Our ref: NE/2014/121520/01-L01
Your ref: S6/2014/2292/FP
Date: 31 October 2014

**Lands Southeast Of Northaw Road East (Cattlegate Farm), Cuffley,
Hertfordshire, EN2 8AU**

Installation of pipework to provide a primary distribution heat network.

Objection

Drawing Title:-
WATERCOURSE CROSSING DETAIL (NORTHAW BROOK)

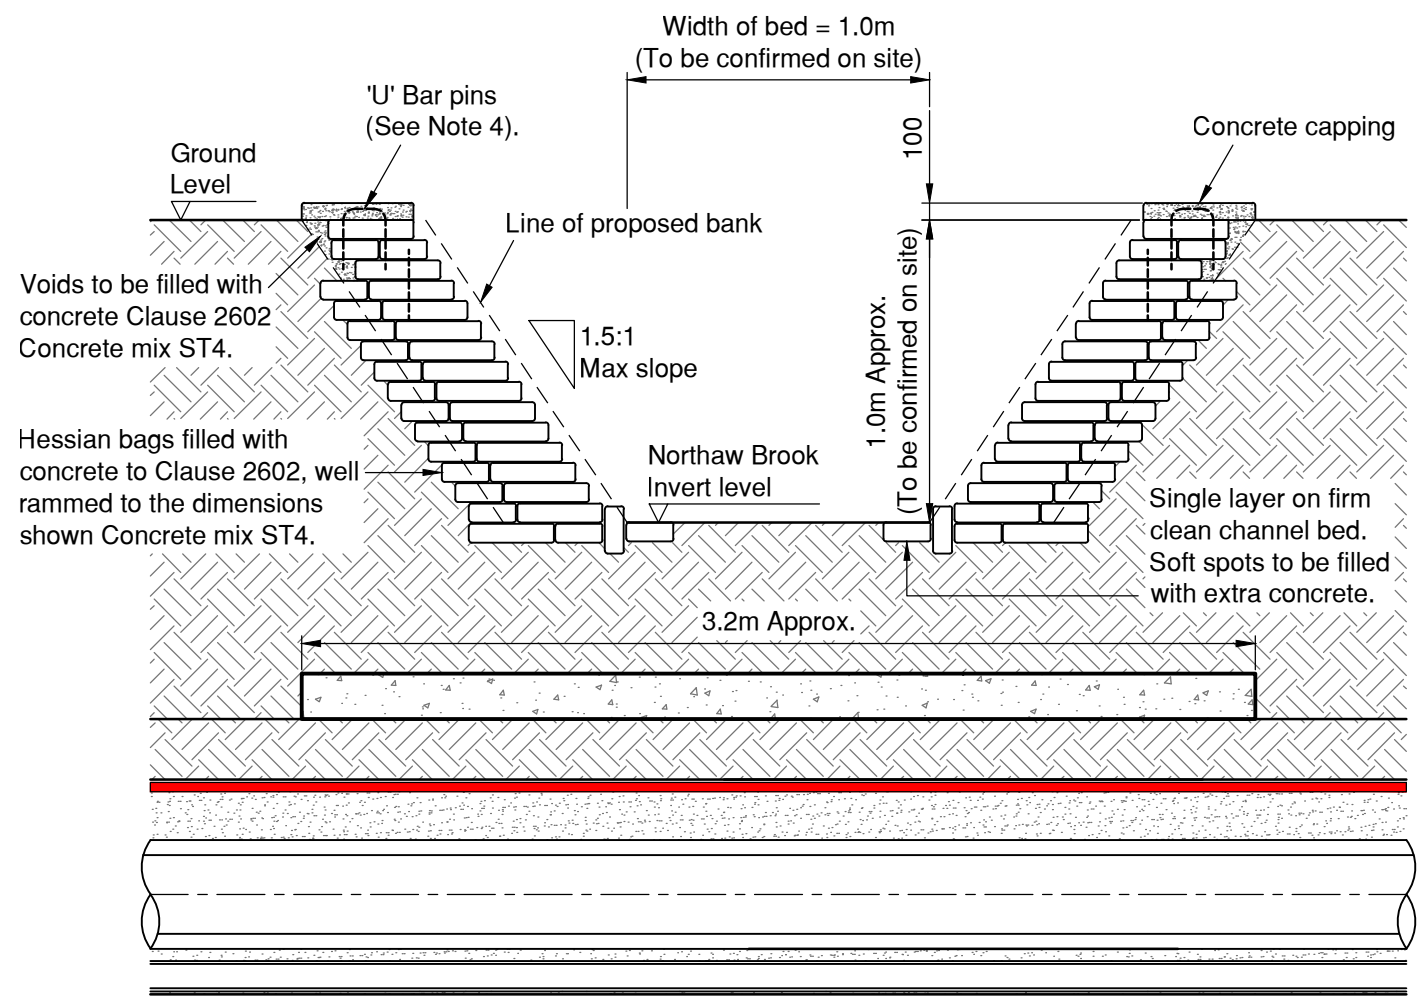
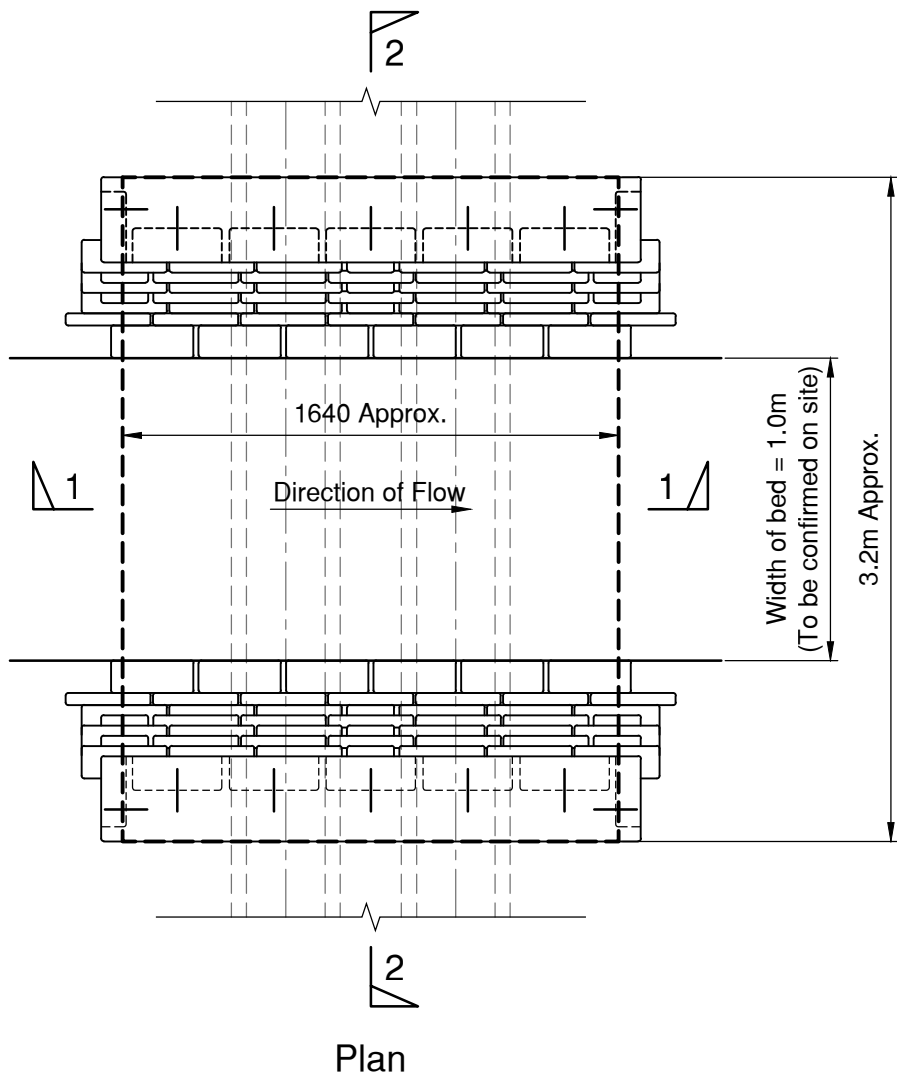
As well as addressing the flood risk, we need to know how the pipes are going to cross both the Northaw and Hempshall brooks (both designated main river). We would expect the pipes to go under the rivers which would reduce the impact on the watercourses.

Should they be crossing over the rivers you may need to carry out a Water Framework Directive (WFD) assessment. This assessment is required for any proposals that impact on a river. A fundamental requirement of the WFD is for water bodies to achieve Good Ecological Status and ensure that deterioration is prevented.
